Application No: FG/212/21/HH
Site Address: 2 Barbary Lane Ferring BN12 5JB
Description of works: Single storey rear extension with balcony.

Thank you for your internet representation made on 4th January 2022 which has been recorded as an objection with the comments as follows:

Proposed East 1:100

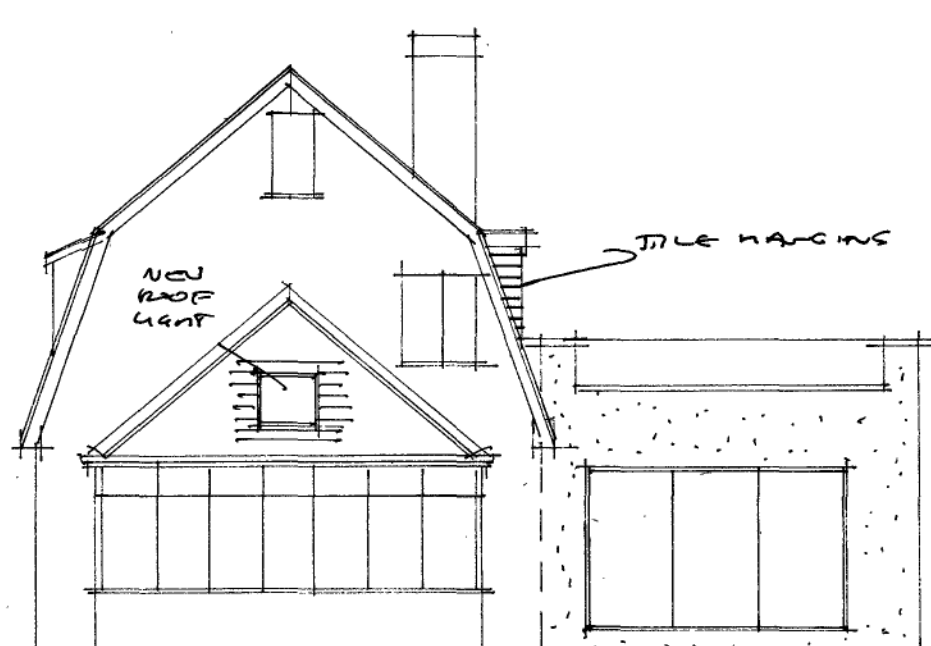
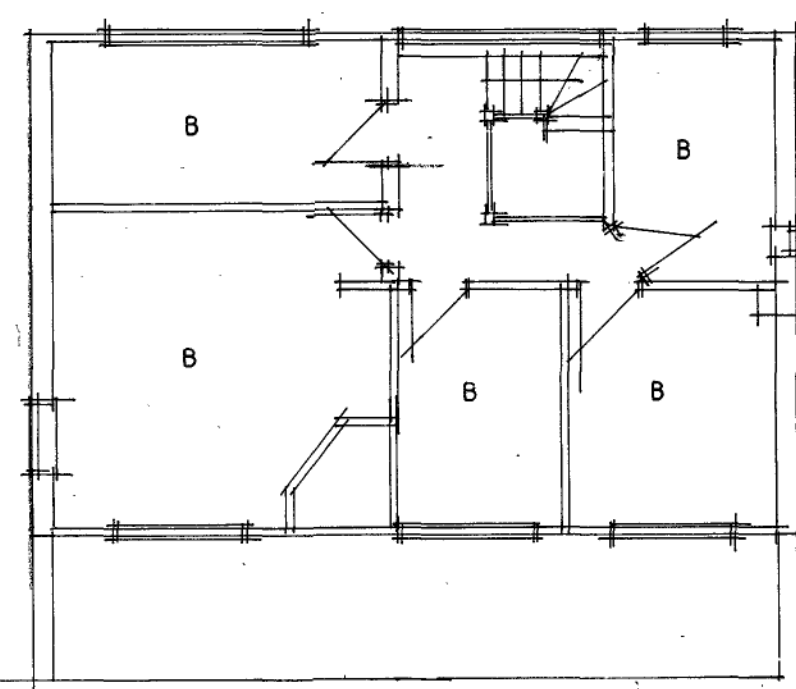
Ferring Parish Council objects to this application due to the extent of the proposed first floor balcony. At only 9.5 metres from the boundary this will create a dominant intrusion overlooking the rear garden of the neighbouring property. Notwithstanding the windows in the existing building, such a large balcony will provide potential for gathering and be considerably nearer to the boundary. This will have an adverse impact the privacy and amenity benefit of the rear garden for residents particularly of the property immediately to the east of the site.
